About the application

Application number: 2020/93863	
What is the application for?:	Erection of pigeon shed
Address of the site or building:	Land off, Deer Hill End Road, Meltham, Holmfirth, HD9 5PT
Postcode:

SITE PLAN
SCALE 1:500

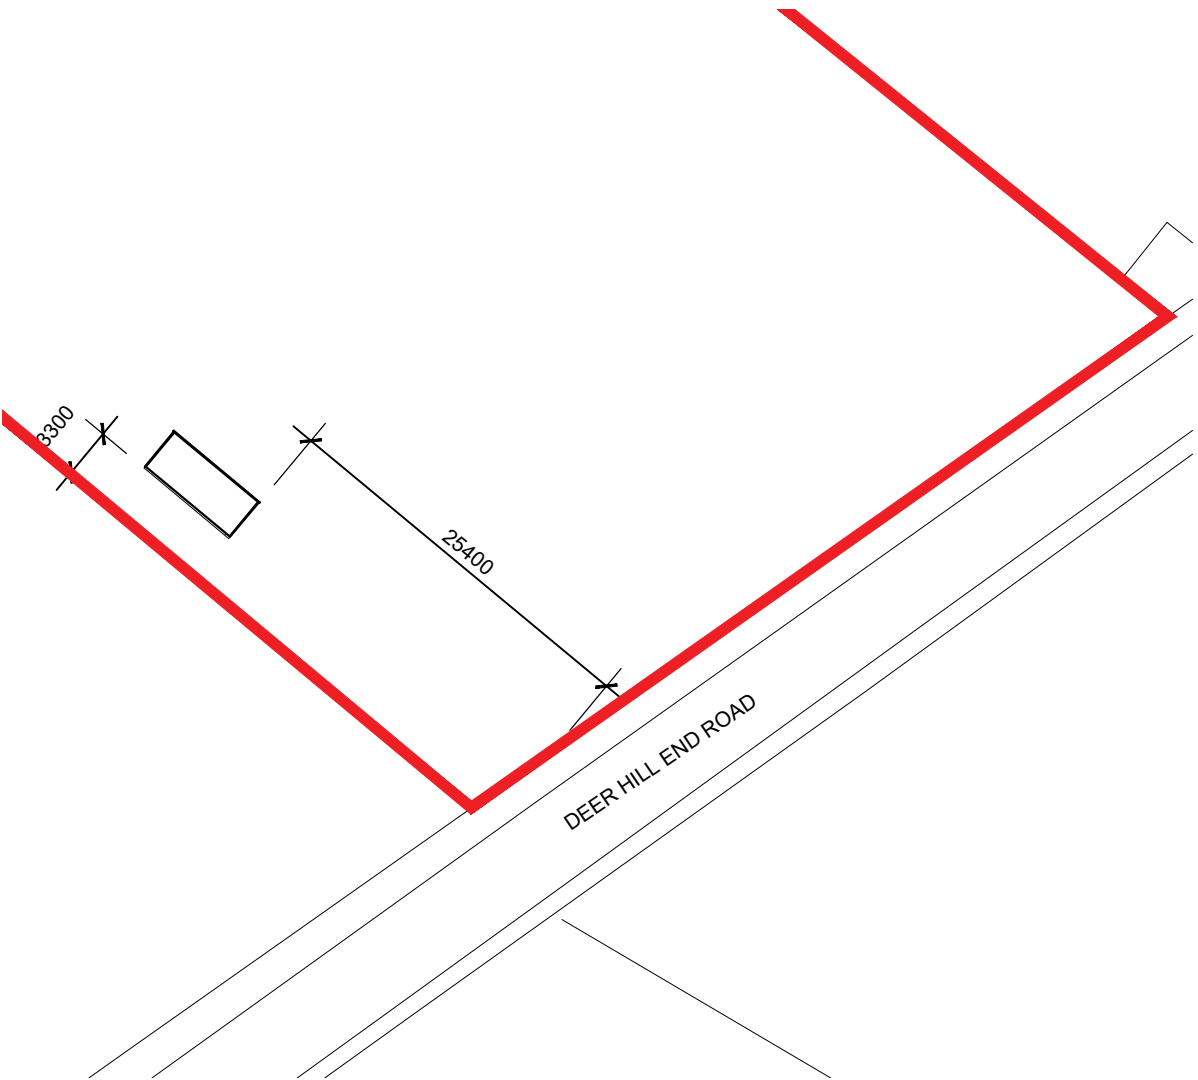
Type of comment: A general comment
It has come to our attention looking in close detail at the map supplied with the planning application, that the pigeon shed has been drawn as located in the wrong field on the plan. It is shown to be in the adjacent field to where it actually is, further away . As such, the plan submitted does not accurately reflect that the pigeon loft and its associated activities This surely will need to be corrected and amended before the application can be properly considered?
